**KIRKLEES METROPOLITAN COUNCIL
INVESTMENT & REGENERATION SERVICE**

Reference no. 2024/CL/90544/E

**Site Address Castle House, Castle Hill Road,
Gomersal, Cleckheaton, BD19
4HW**

**Description Prior notification for demolition of
buildings and erection of one
dwelling**

EXISTING SITE PLAN 1:250 @ A1

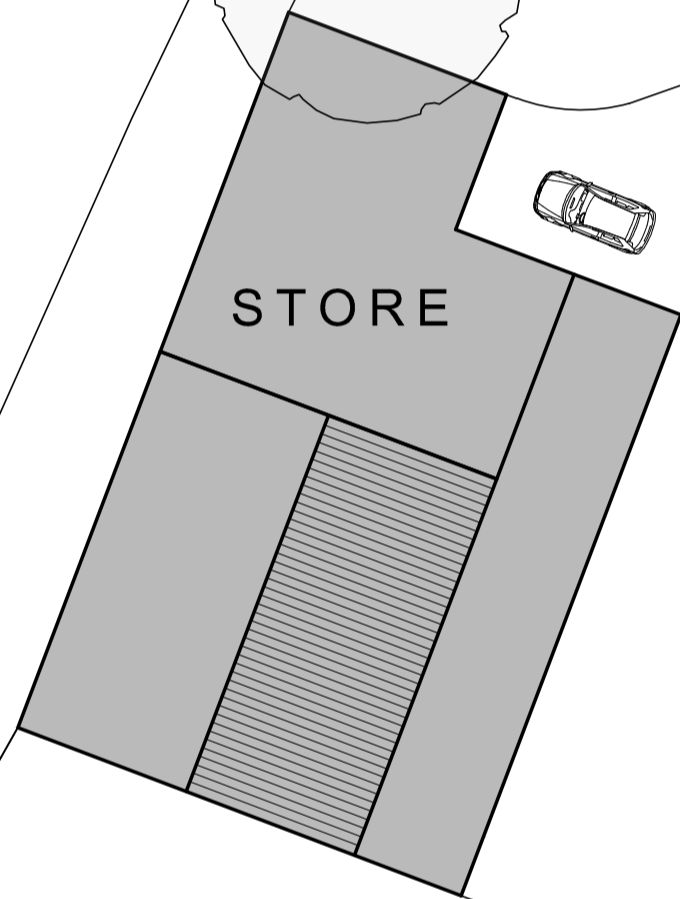
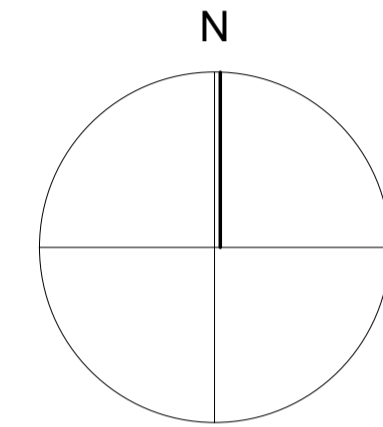
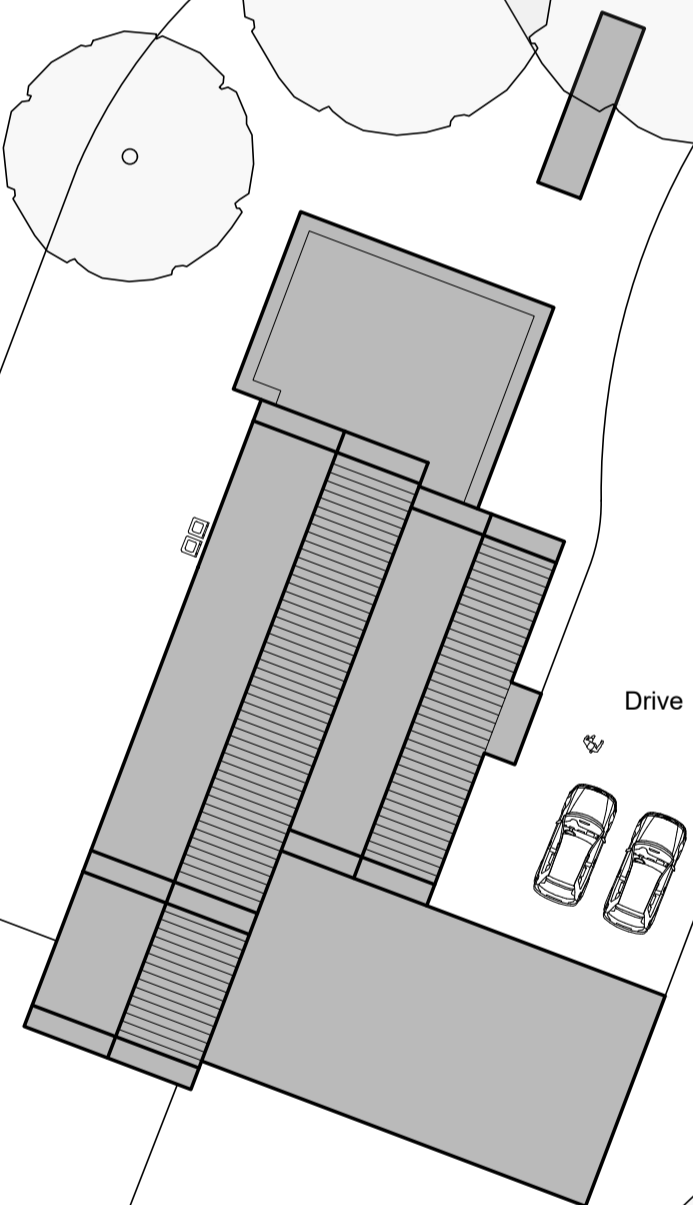
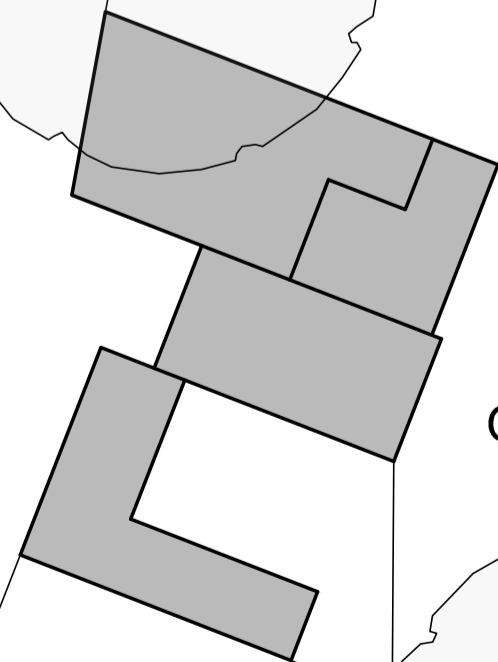
Informal consultation with KC Highways 17/04/2024: An updated site plan would be required which demonstrates 2.4x43M visibility splays.

The site plans provided indicate two parking spaces in conjunction with the dwelling; however, there is a large amount of hard standing associated with the existing unit.

KC Highways have not raised any objections to the application providing that a 2.4mx43m visibility splay can be demonstrated along Castle Hill Road.

PROPOSED ELEVATIONS 1:100 @ A1

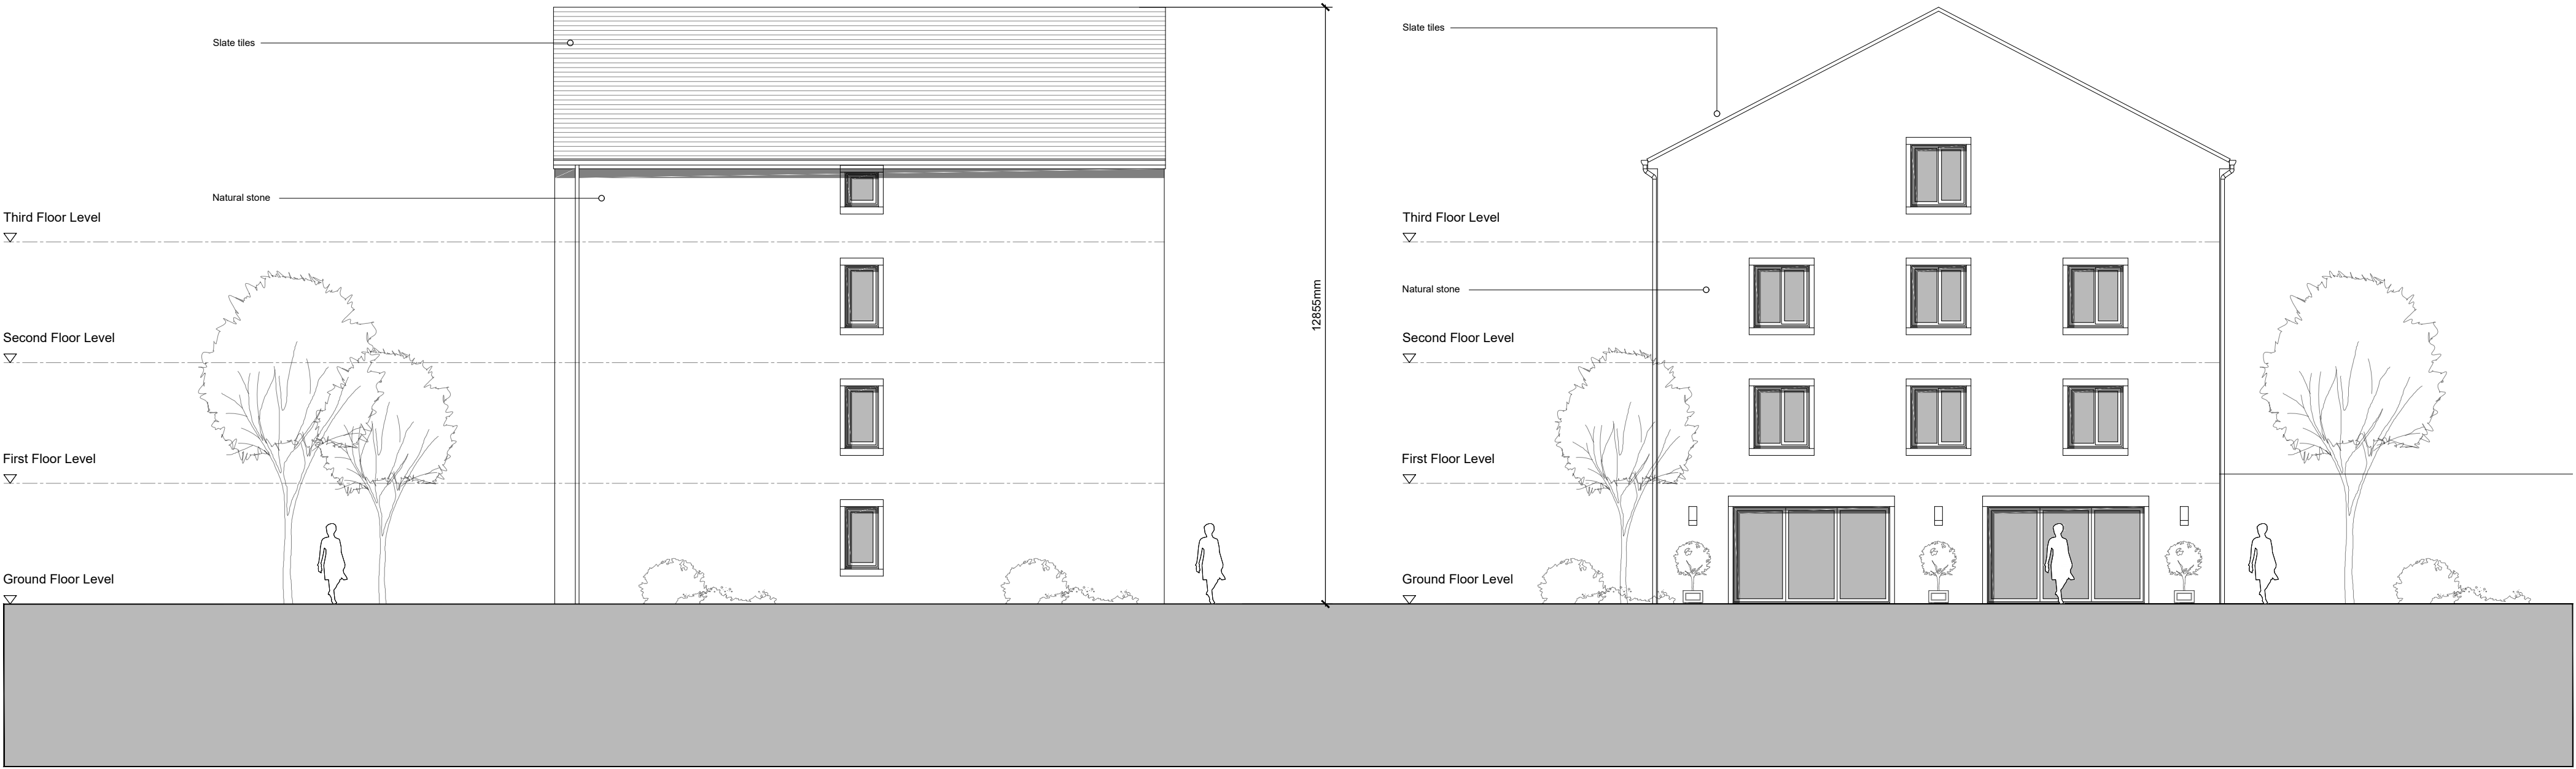
The replacement building would feature four floors with a maximum height of 12.8m with an eaves height 9.6m. This would feature a pitched roof. The proposed would be constructed in stone with slate.

It is considered that the proposed structure would have a maximum height of 13m and feature four storeys of accommodation, officers have considered the

context of the site and its relation to neighbouring development and considered that the scale and design of the proposal would not be in keeping with development in the immediate vicinity of the site.

It is acknowledged that the proposal would be set some distance from the public realm; however, officers consider that the proposal should be reduced in scale to reflect the prevailing character of the area and appear more in-keeping.

It is considered that due to the scale location and design of the proposal would not adhere to policy LP24 in terms of visual amenity.

Overlooking: The proposal would feature 11 windows on its eastern elevation which would be 19.7m away from the rear of Castle House. It is considered that the usual acceptable separation distance between habitable room windows is 21m and therefore there would not be sufficient separation distance between the properties to limit an unacceptable overlooking relationship. This would be discordant with principle 6 of the house builders design guide SPD.

Overbearing: The proposal would be located to the west of Castle House and 19m away. It is acknowledged that it is the rear of Castle House which would be impacted by the proposal, but it is considered that the increased scale of the proposal in conjunction with the reduced separation distance would result in an unacceptable overbearing relationship to the occupiers of Castle House.

PROPOSED FLOOR PLANS 1:100 @ A1

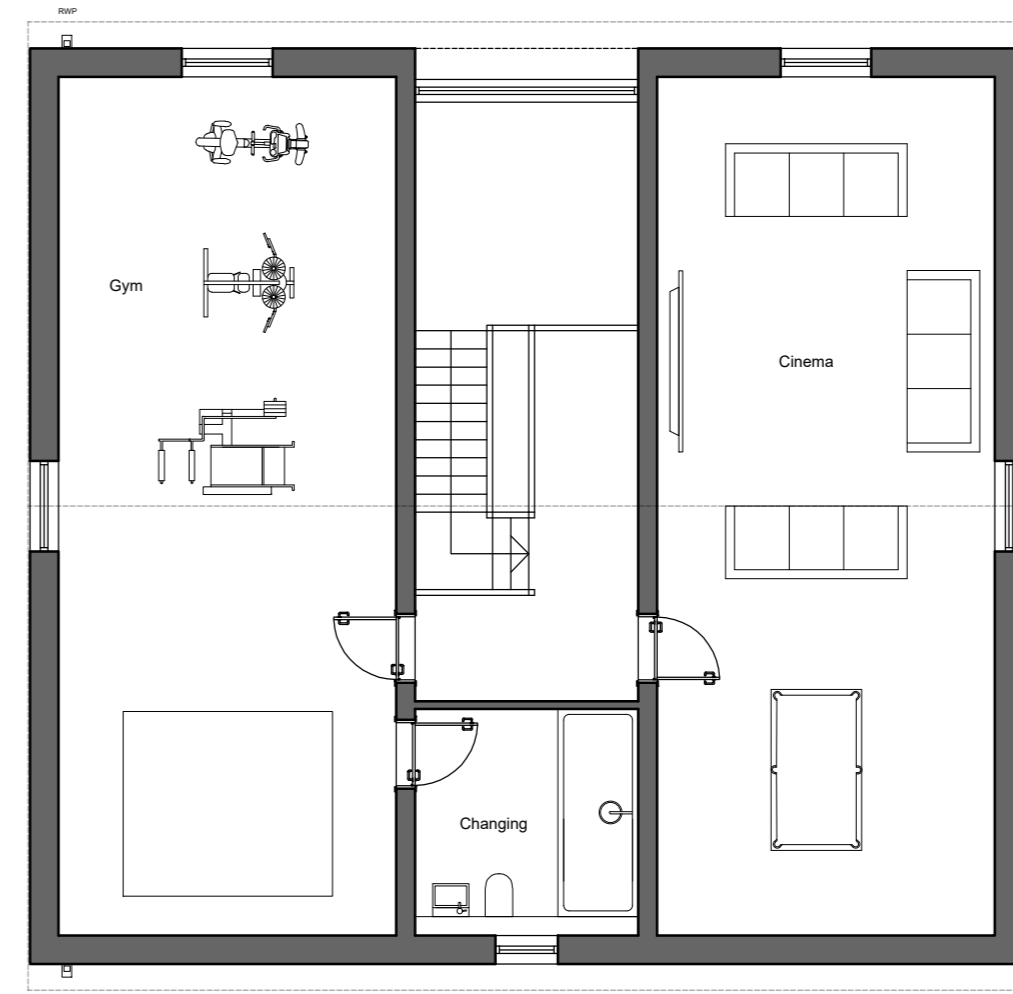
Officers have reviewed the floor plans provided to support the application and all rooms have been provided with adequate fenestration on all elevation.
